**Re: Status of Improvement Permit Application #1807-0042
3018 Old Stage Road**

*Newapp#
BRES 1908
0022*

An attempt was made to evaluate your property for the purpose of issuing an Improvement Permit. The evaluation could not be completed for one or more of the following reasons.

SURVEY FOR:

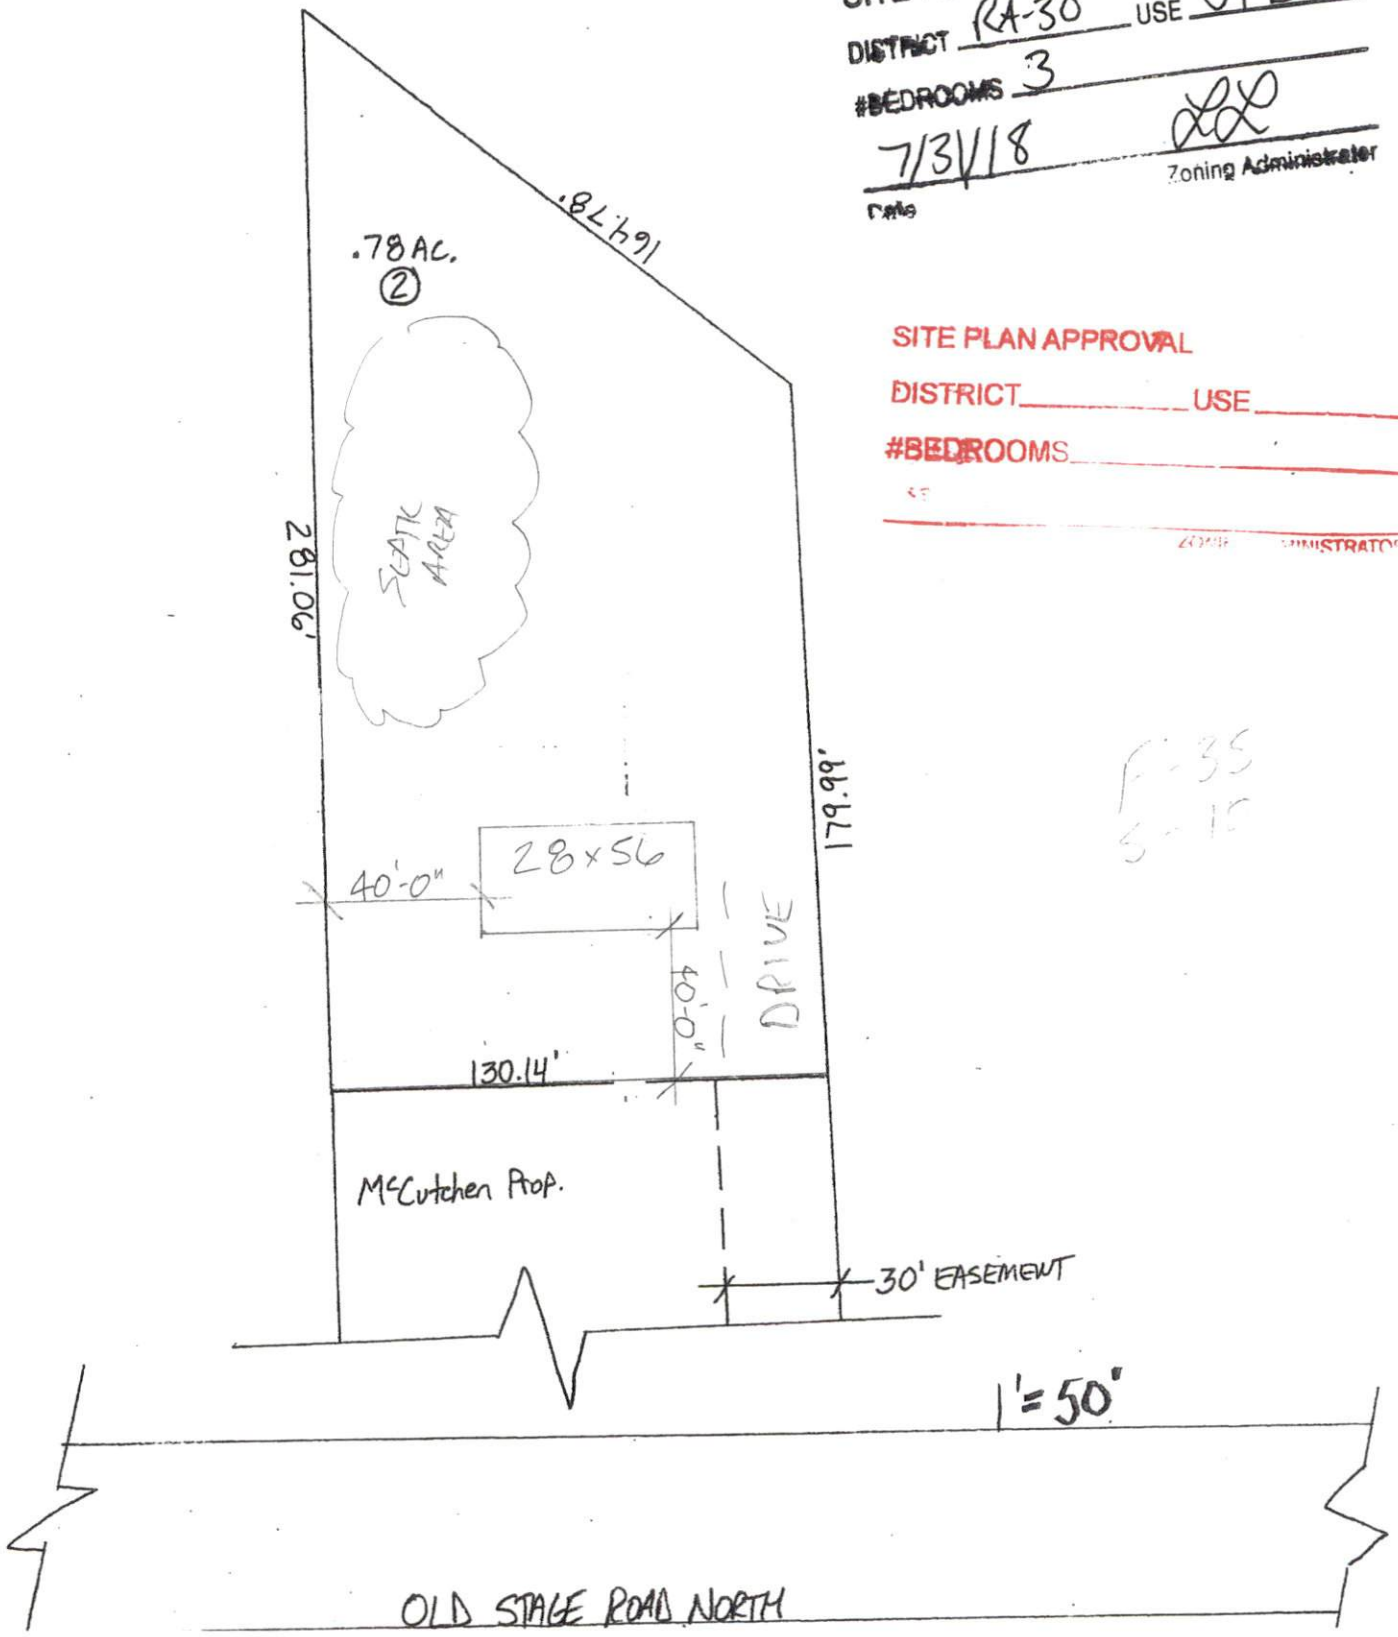
- 1. Use pink flags to mark *property lines and irons that are set by surveyor need to be visible (\$25.00 fee incurred)
- 2. Use orange flags to mark *house corners
- 3. Directions not clear to property (\$25.00 fee incurred)
- 4. Property needs only brush or vegetation removed
- 5. Driveway not shown on site plan
- 6. Backhoe pits required

7. Other – See 1 # and #2 above – *Single-family-dwelling was not flagged on site. Also, *one of two front property irons were not uncovered. Please complete these items.

*Completed
8/19/19
[Signature]
(919)669-8060*
